### ISH2 Weds 7 Dec\_Part3

Yep. Great. Thank you. Okay, so what now? To section four of the agenda, which is cultural heritage.

Drawing file: published-documents / EN010112-000380-6.6.10.5.17_AyM_SLVIA_Fig_44a-g_VP17_Penrhyn_Castle_terrace.pdf

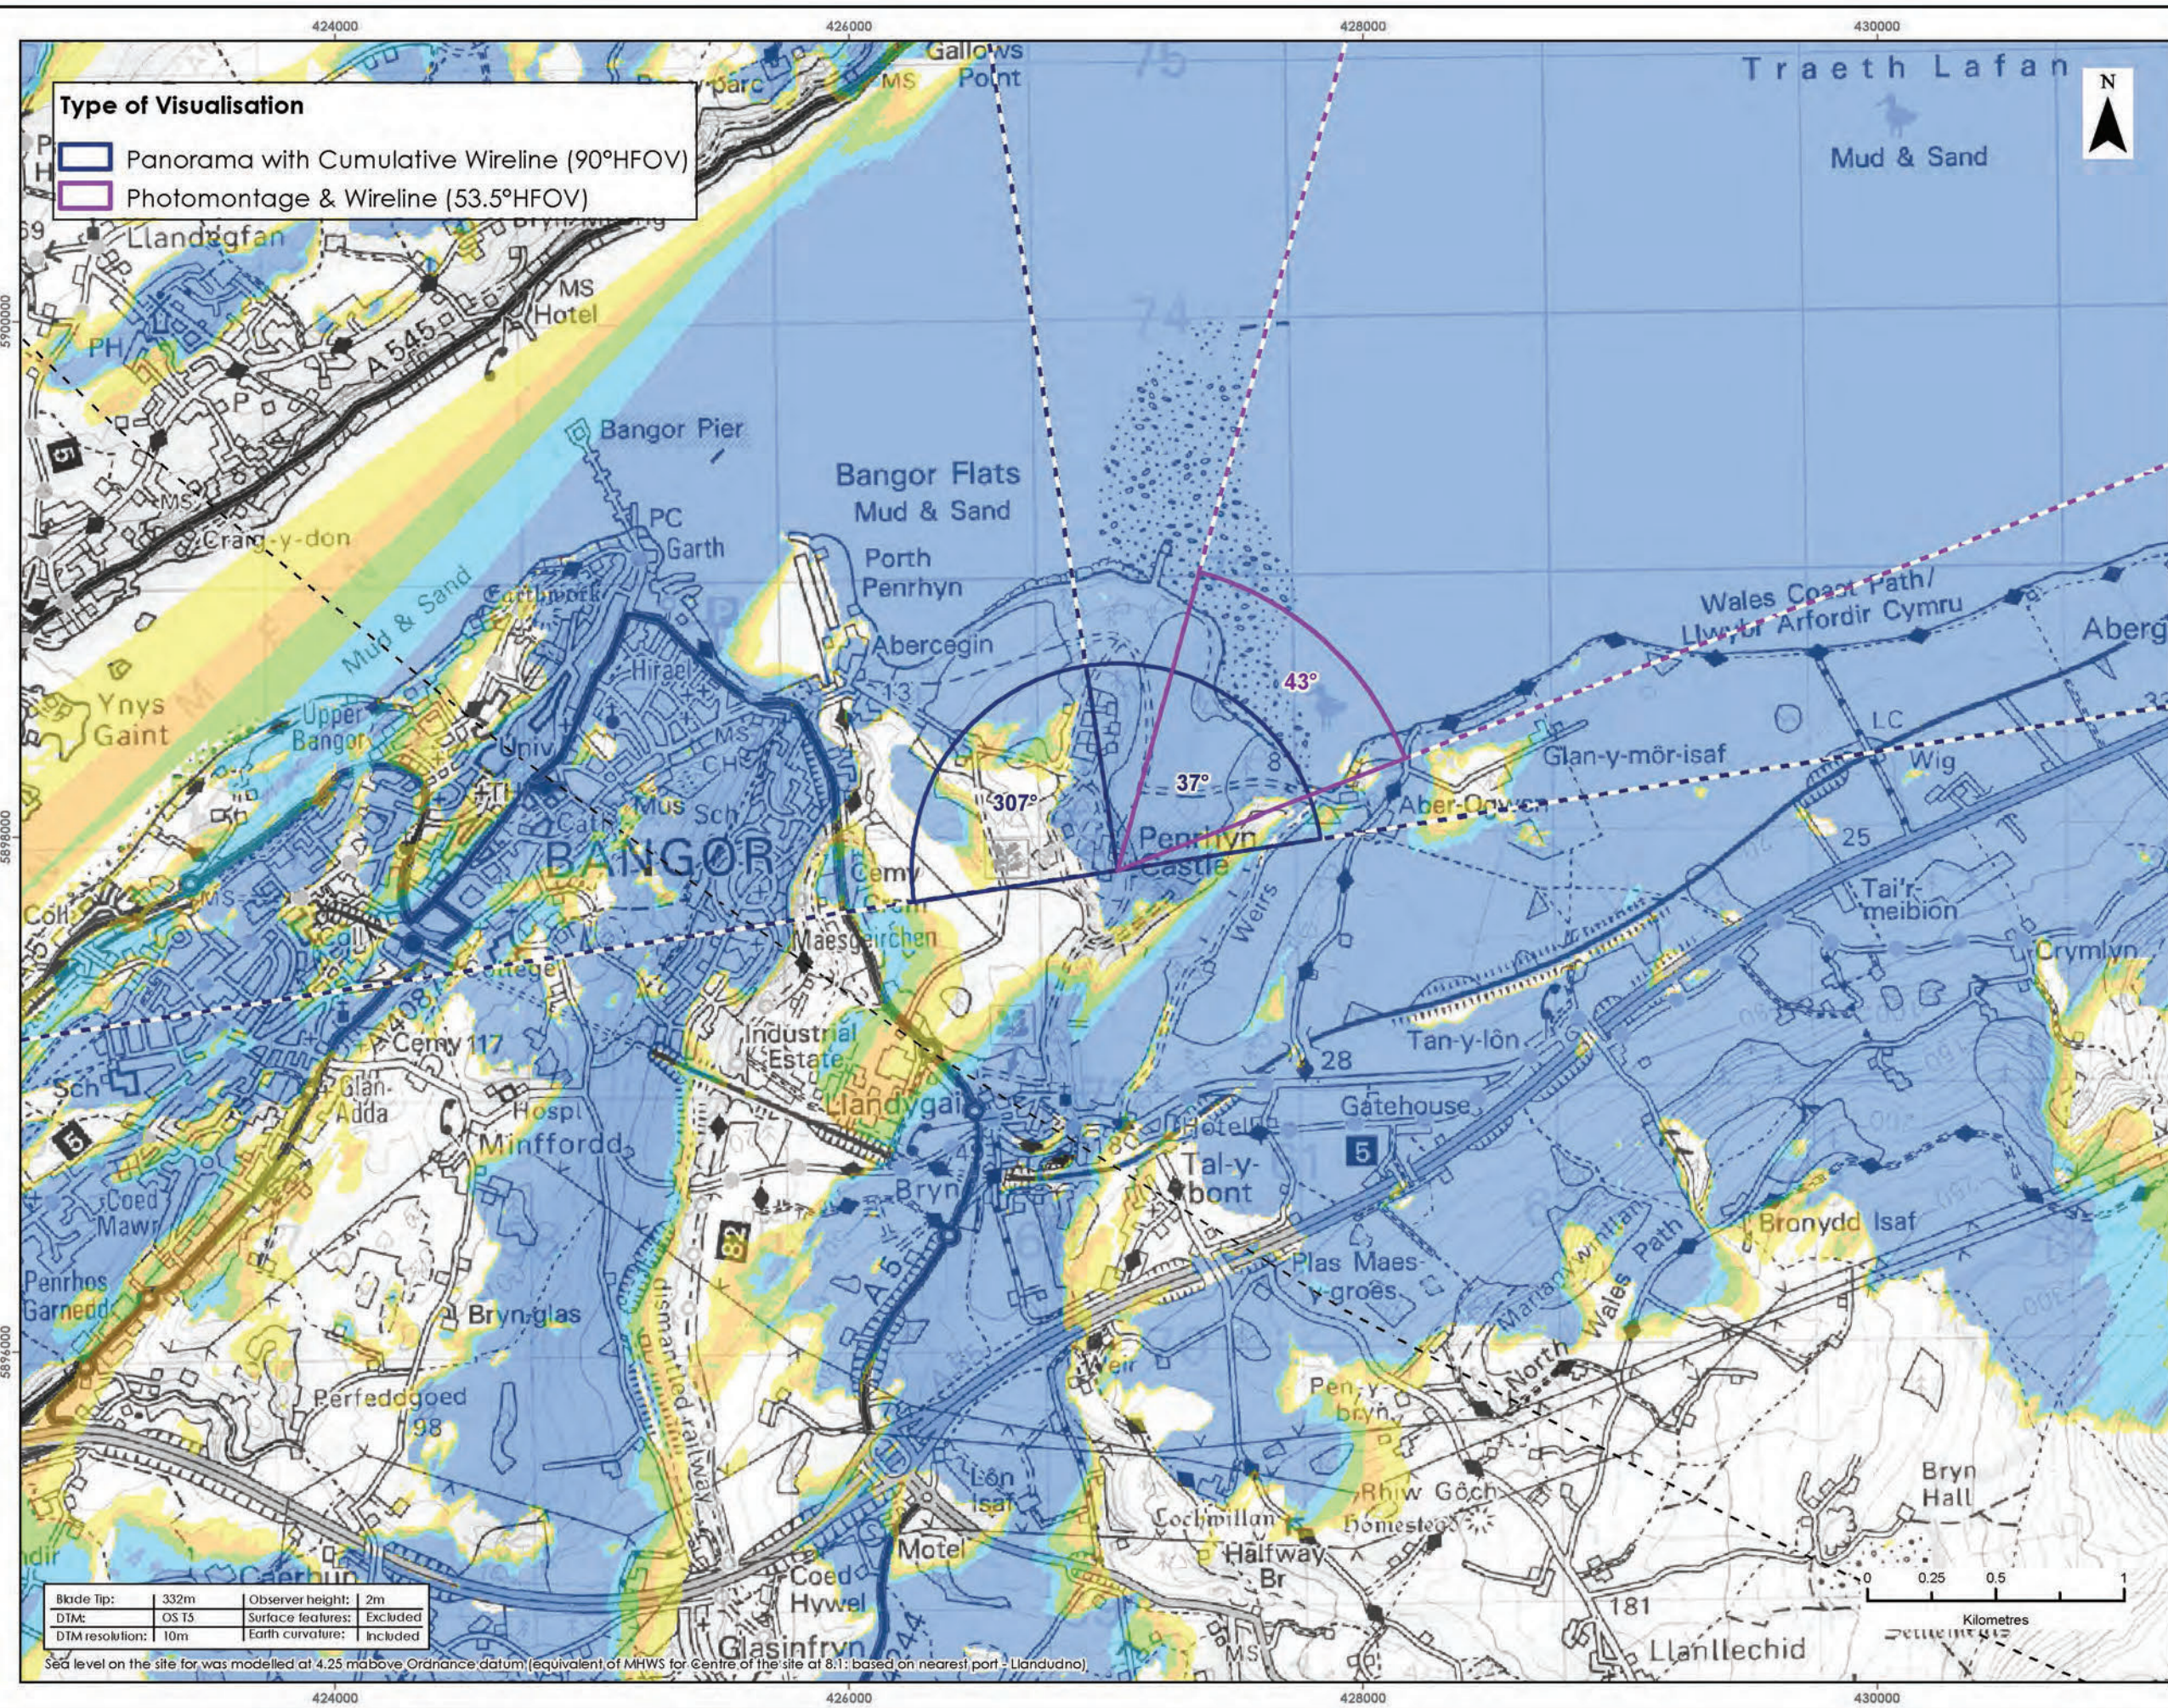
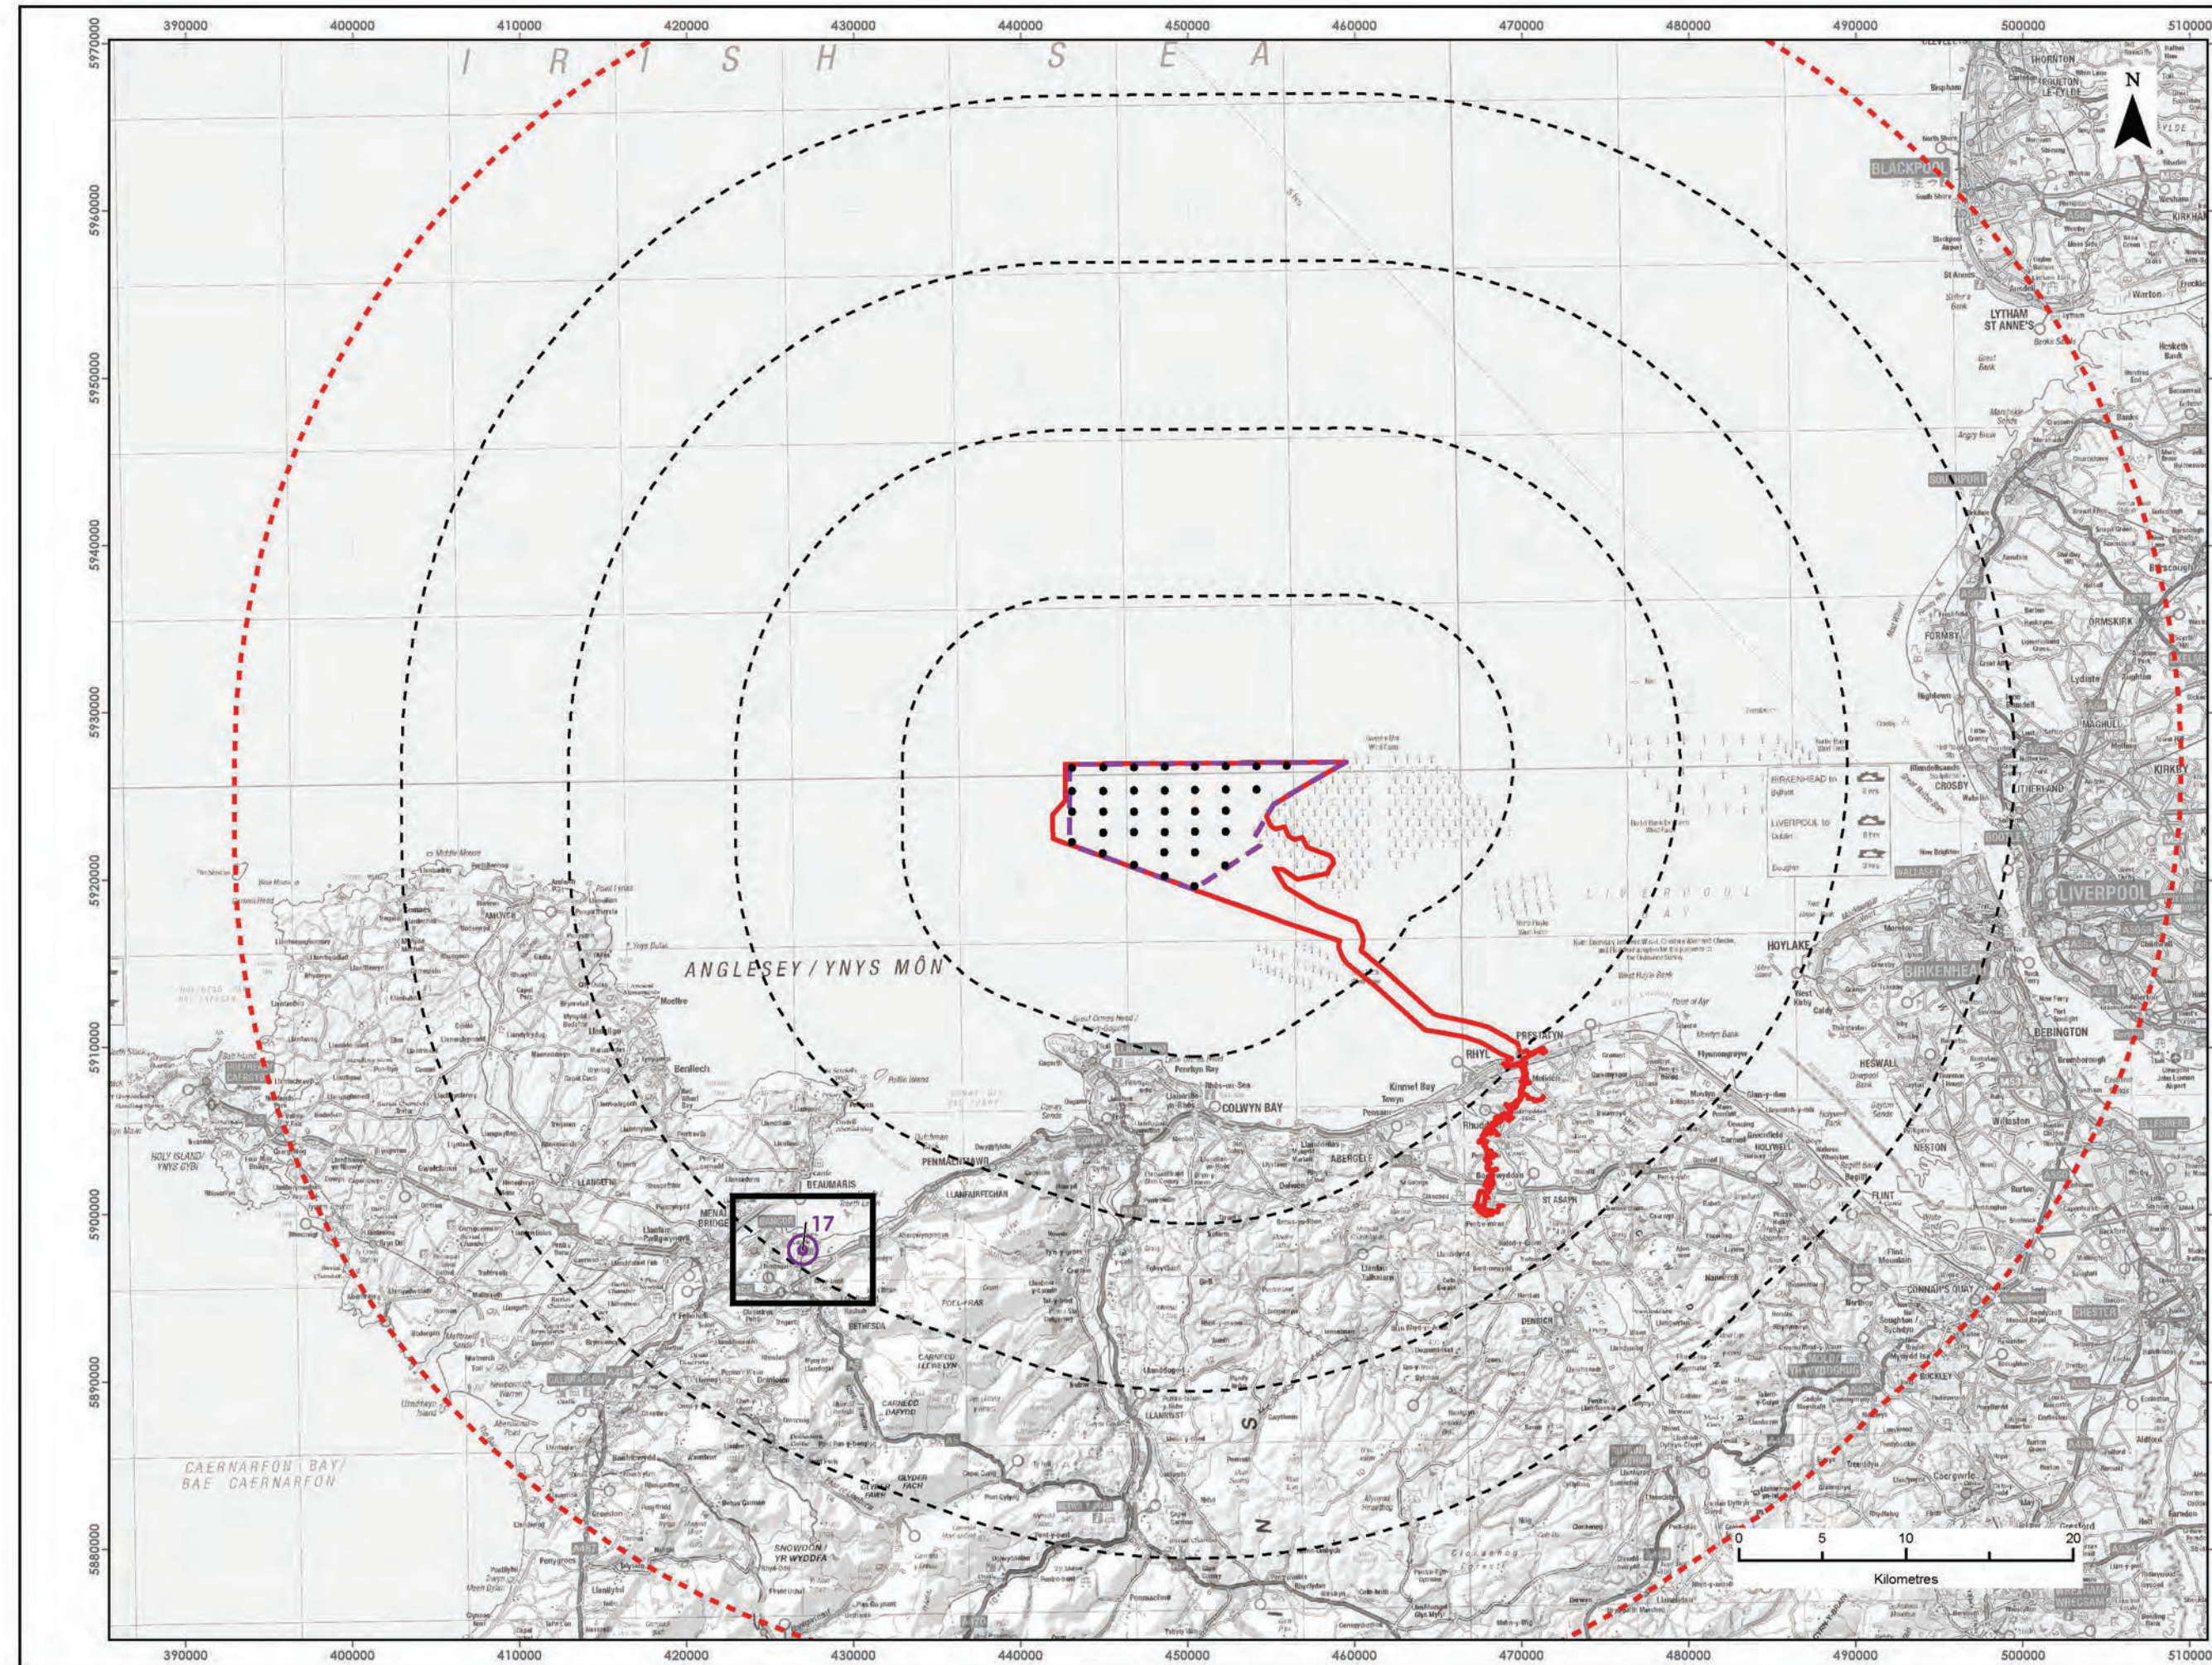
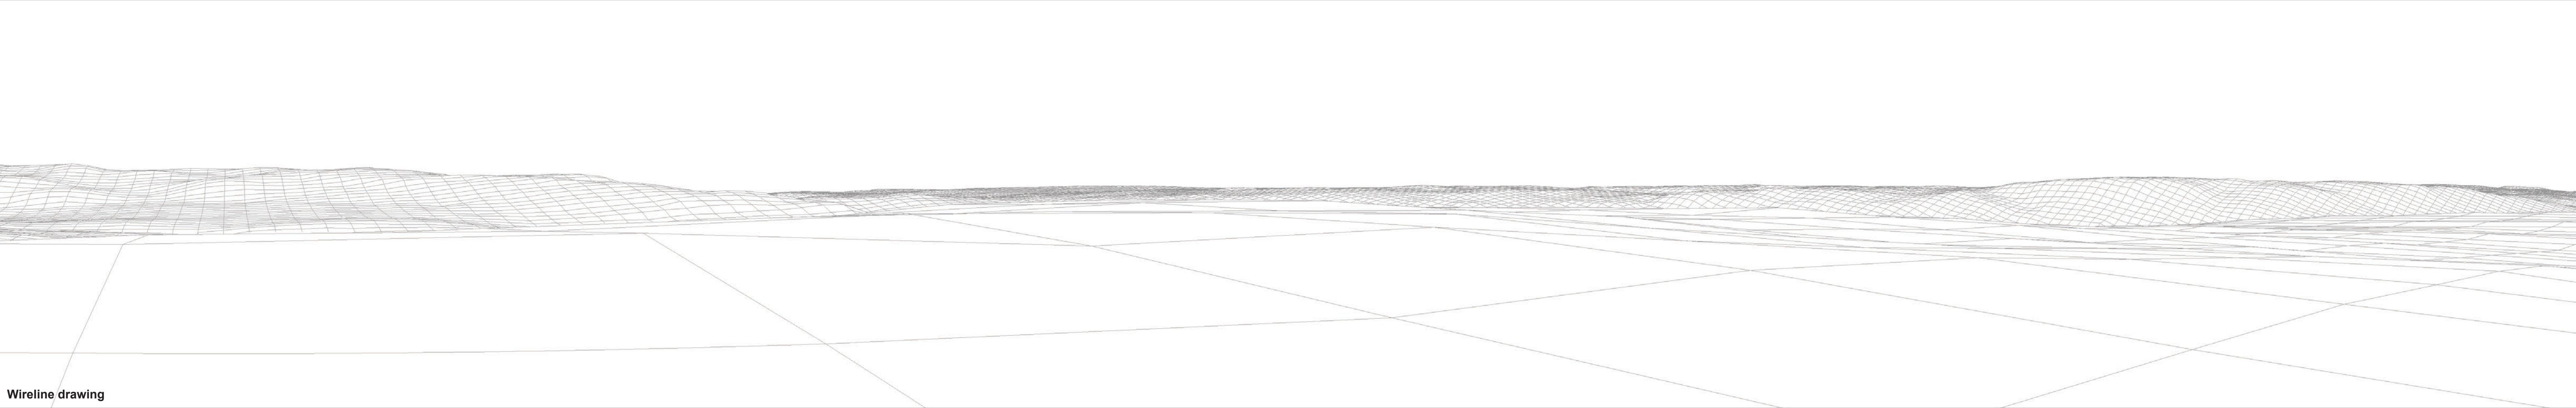
I was just I noted in the end that a listing for the rest of Park and Garden states that significant views include views for the main entrance of the house and the Barbican Terrace, which obviously we have a visualisation from on the east side, offer the best views towards Penmaenmawr and comedy, The view and the quotes. A view of the park, coast and hills is spectacular.

So my question is, would the construction of the project have an effect on those views? Introducing a new element into the largely countryside and seaside based views that are presently recognised in the listing?

you can't just focus on what is not affected. You need to acknowledge what is affected and give that due weight. Is the view from the terrace. Looking out towards the sea is important. It's an intentional view design view and the beauty and scenic quality of that view is important and it looks, it leads the eye to the horizon and as such towards the overseas estates, the plantations and the problematic slavery connection that was the source of the and state.

the new development that the turbines would fill that framed view. It would have me say it would foreshorten the view and detract from the and the experience. I guess that the intended aesthetics of that view. And so in that particular view, I would argue that the the impact is of some significance. It doesn't disrupt the relationship between the estates and seeing it, you know, moving.

And the thing is there's nothing immediately blocking in the in the in the foreground, but it is a conspicuous impact on that one setting and reduces the contribution of that view

Mark TONER on behalf of the applicant. It will certainly introduce something new in view. But it's the question I need to consider is to a degree, the view and what's in the view contributes to your ability to understand the Council's significance in terms of its other interests in the round and what part that plays in terms of the role of the park surrounding it as an appropriate setting for the castle and whether that's an armed.

In my view, whilst there is an addition in the view it does not so materially change the contribution made by the setting in the round to how you appreciate the castle when you circulate within its setting.

That the significance doesn't rely solely on that view. And in my view, you can still experience the intended relationship with the C, and I accept there are some design views throughout that landscape in different directions.

I don't believe that having the turbines in my view, prevents your association or understanding of the intentionality of the landscape in the design planting either in the case of that individual view or in the round.
